# ENG-CDR20005-V1-CD-Marksheffel-Redlines Summary\_Markup Summary

PEDESTRIAN INTERSECTION RAMP (SD 2-41)

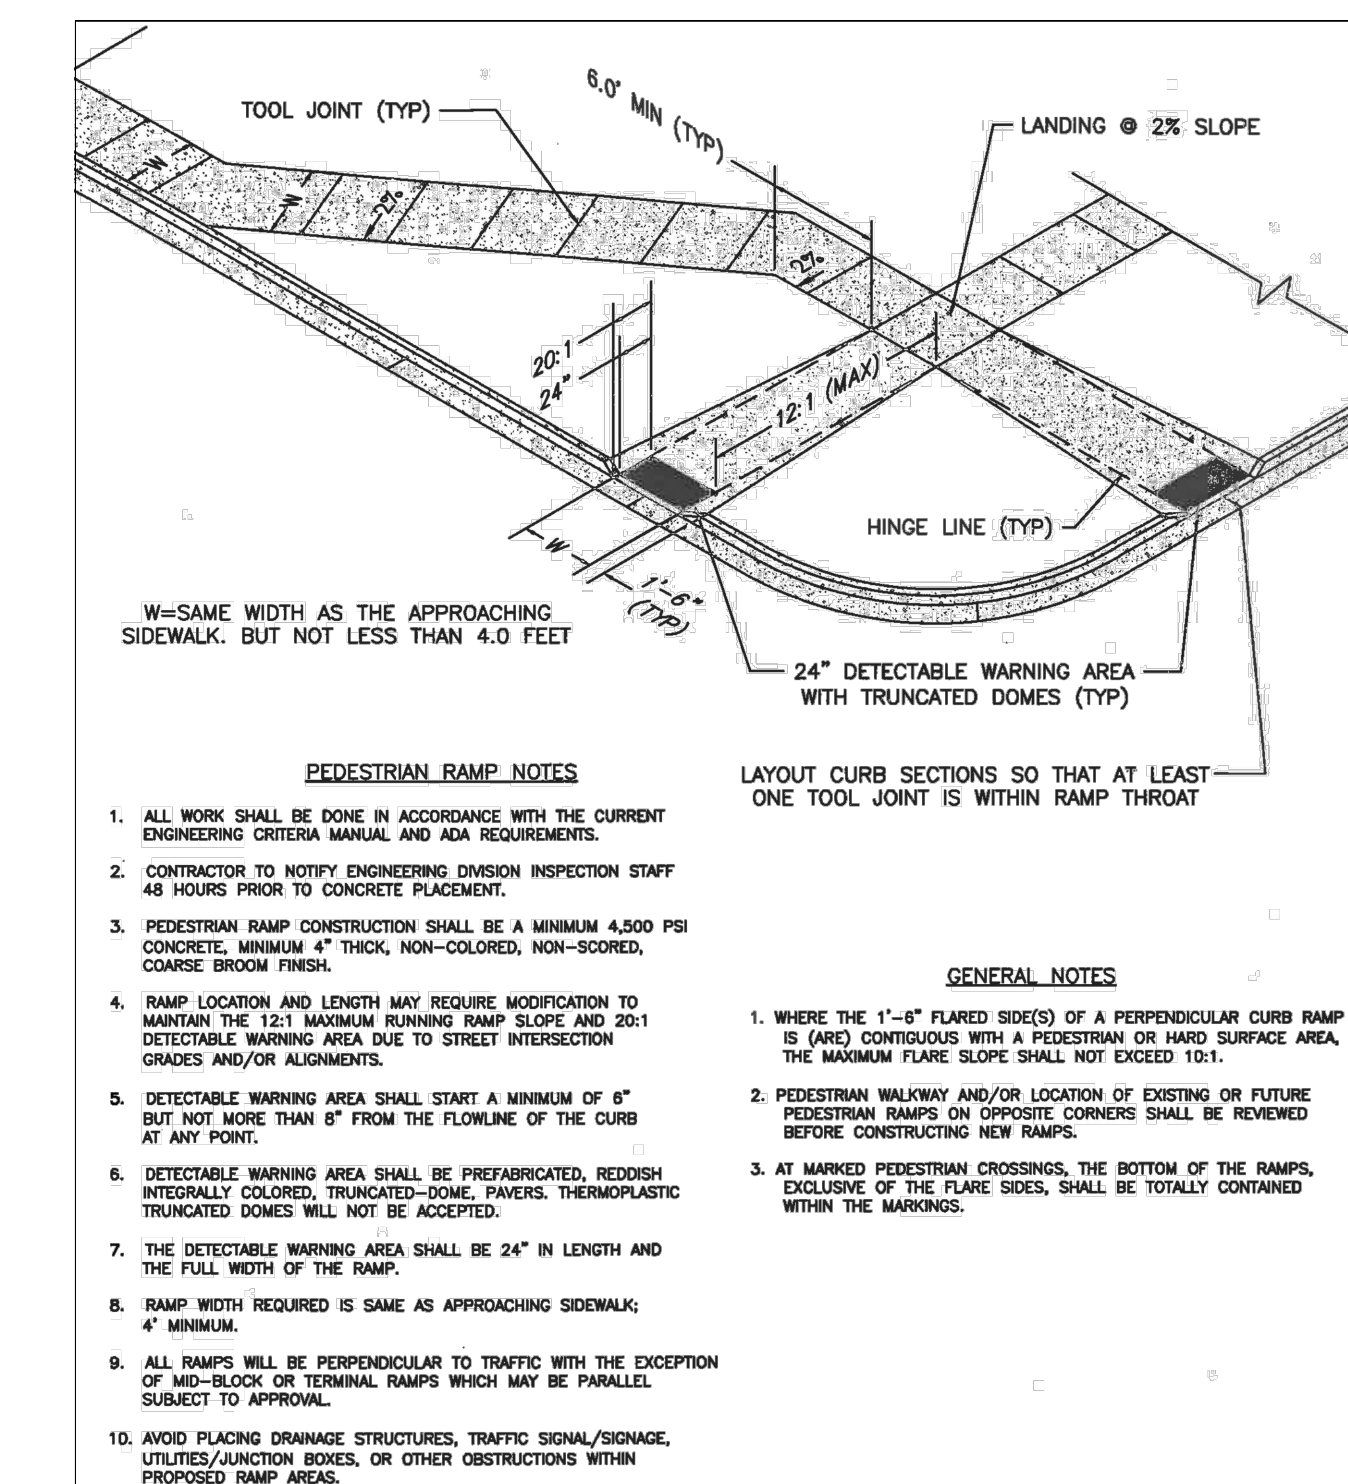
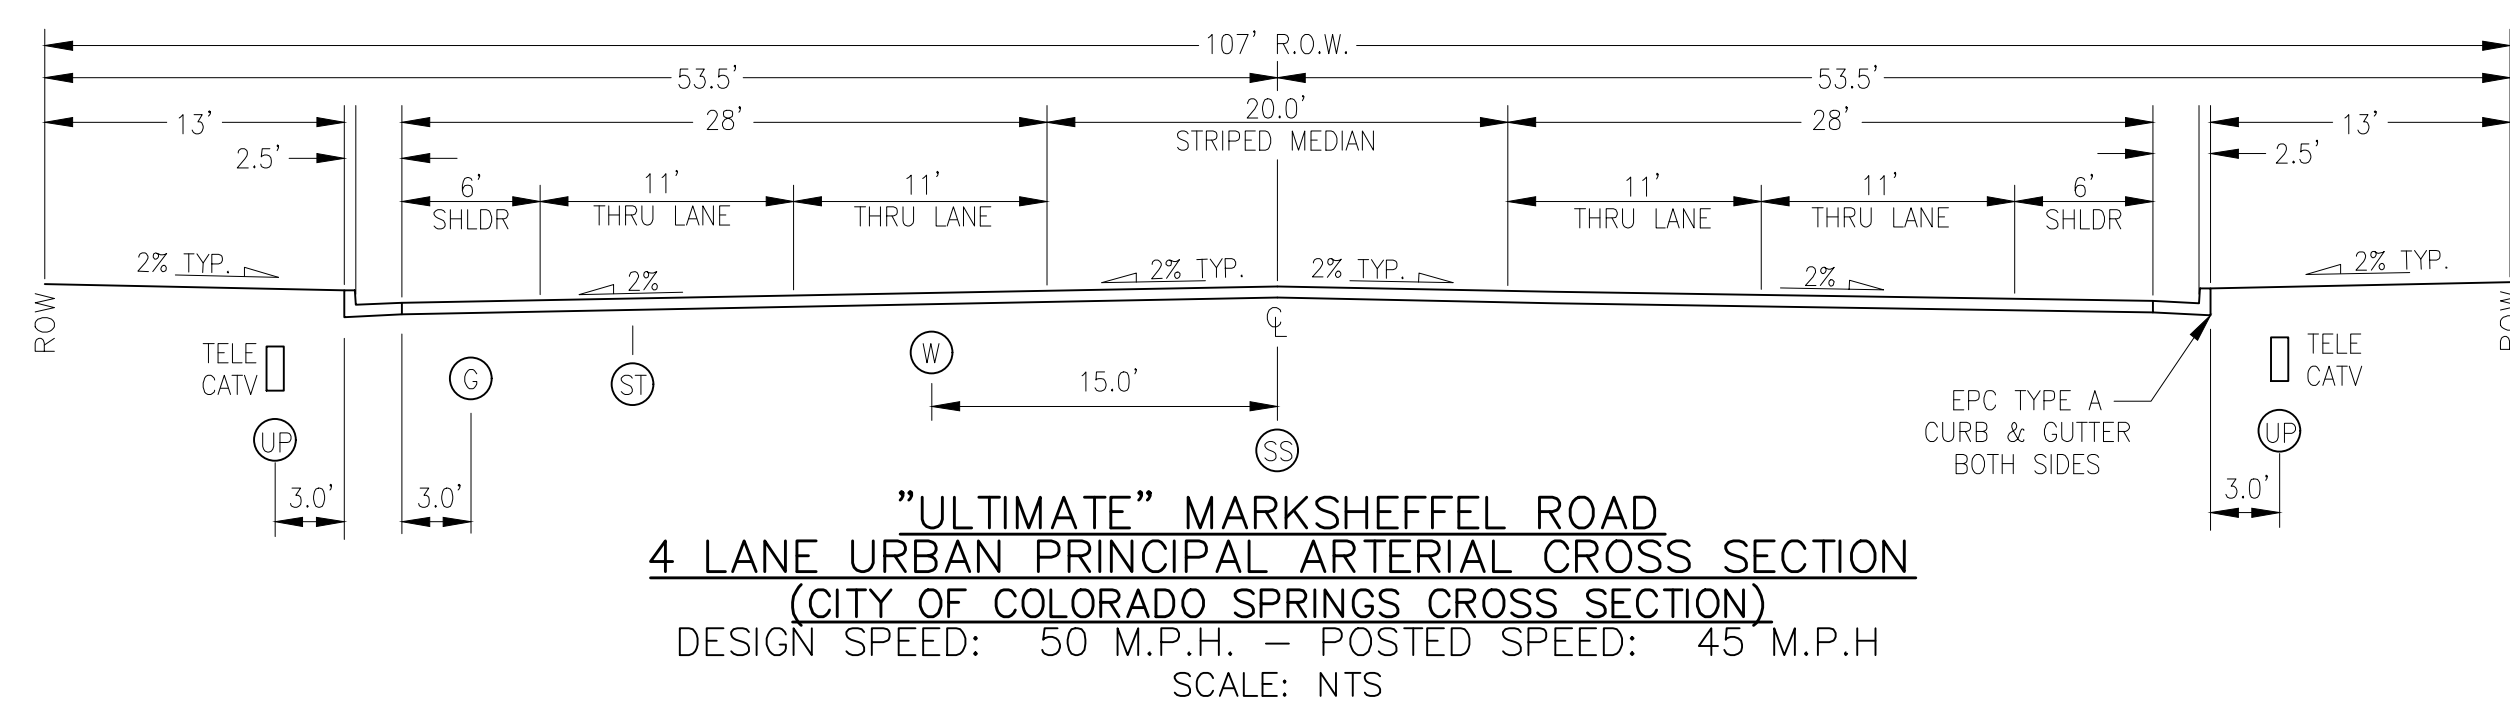
Verify compliance with new Chapter 6 and std details.

Is the City going to accept this?

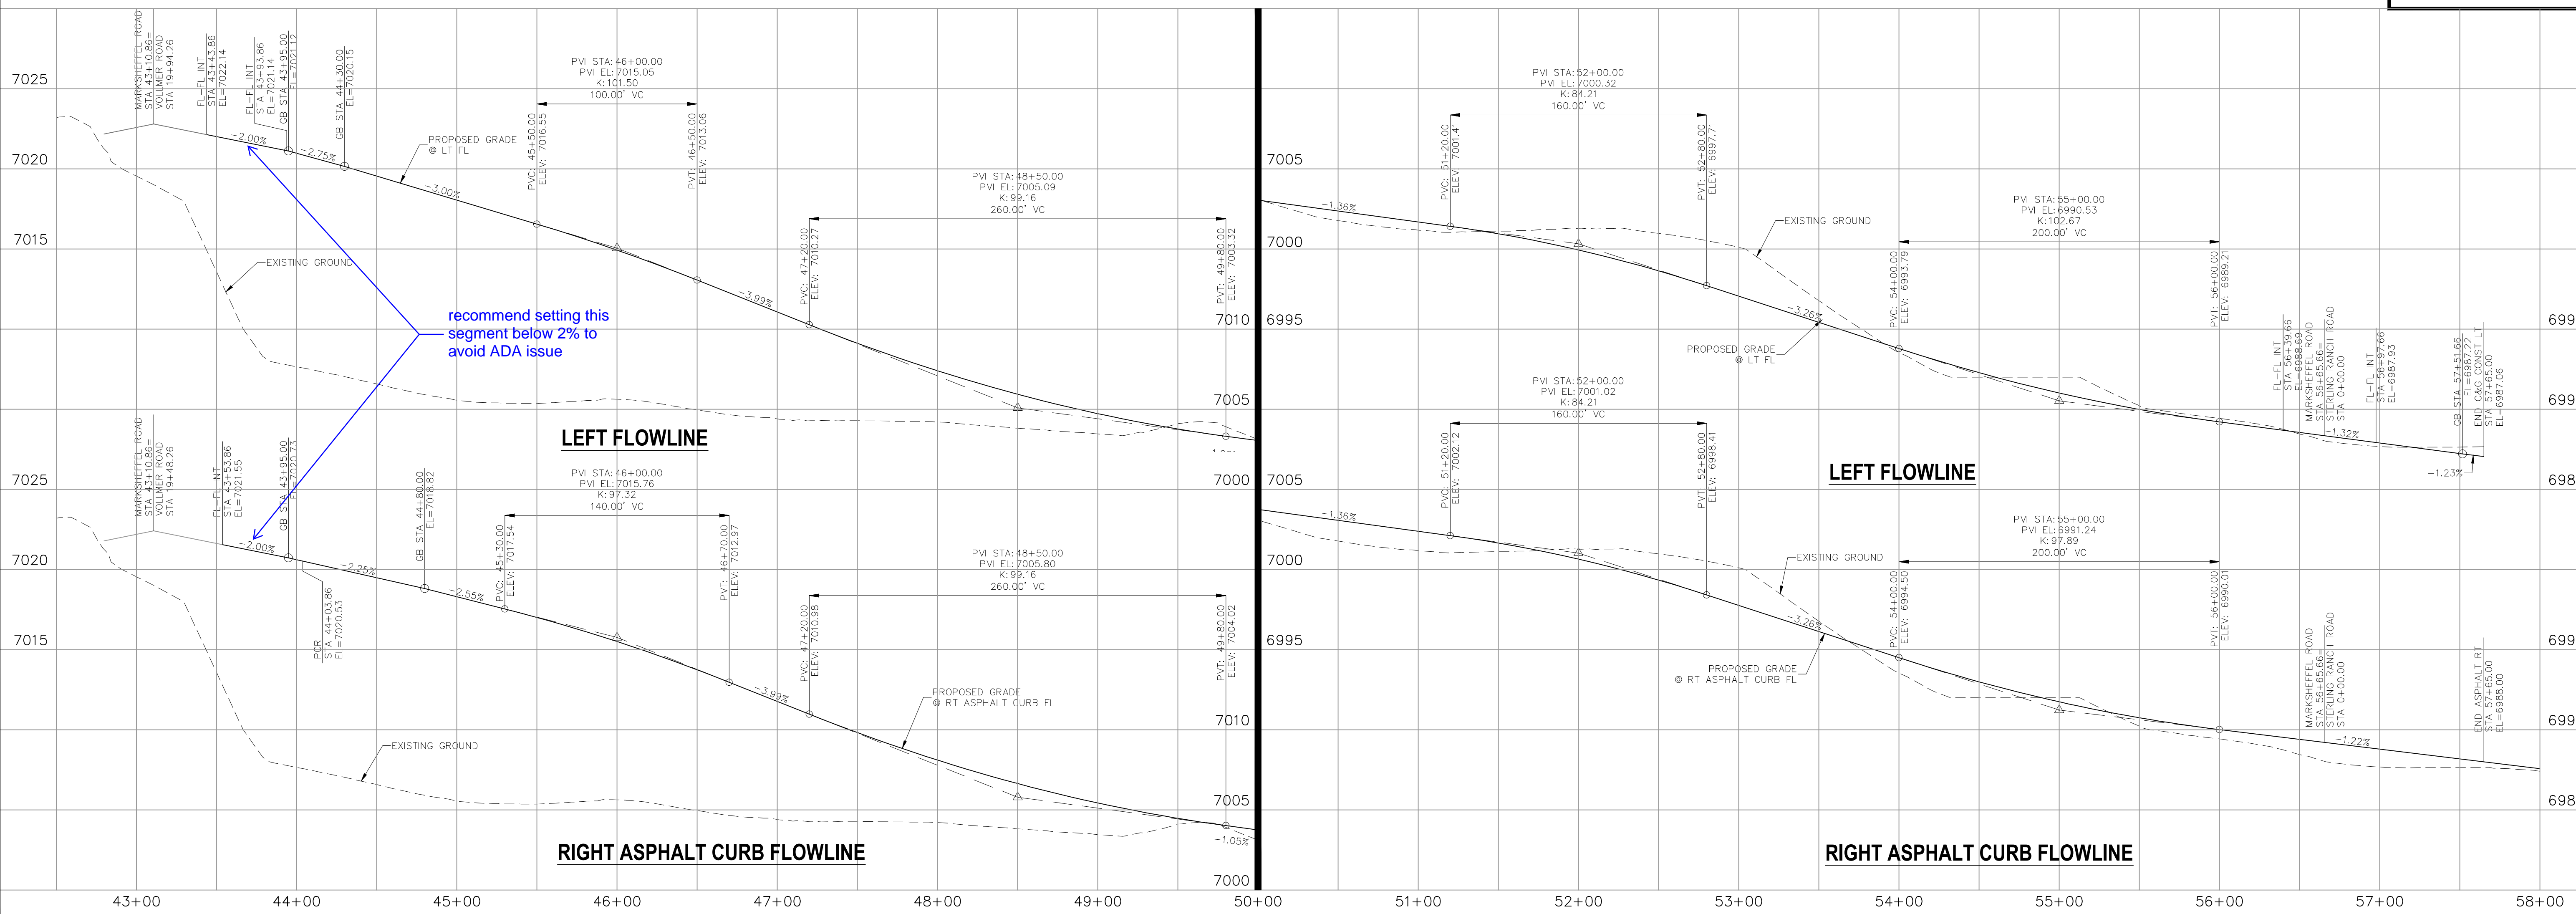
This needs to be built with the roads if the roads are preceding Filing 2

recommend setting this segment below 2% to avoid ADA issue
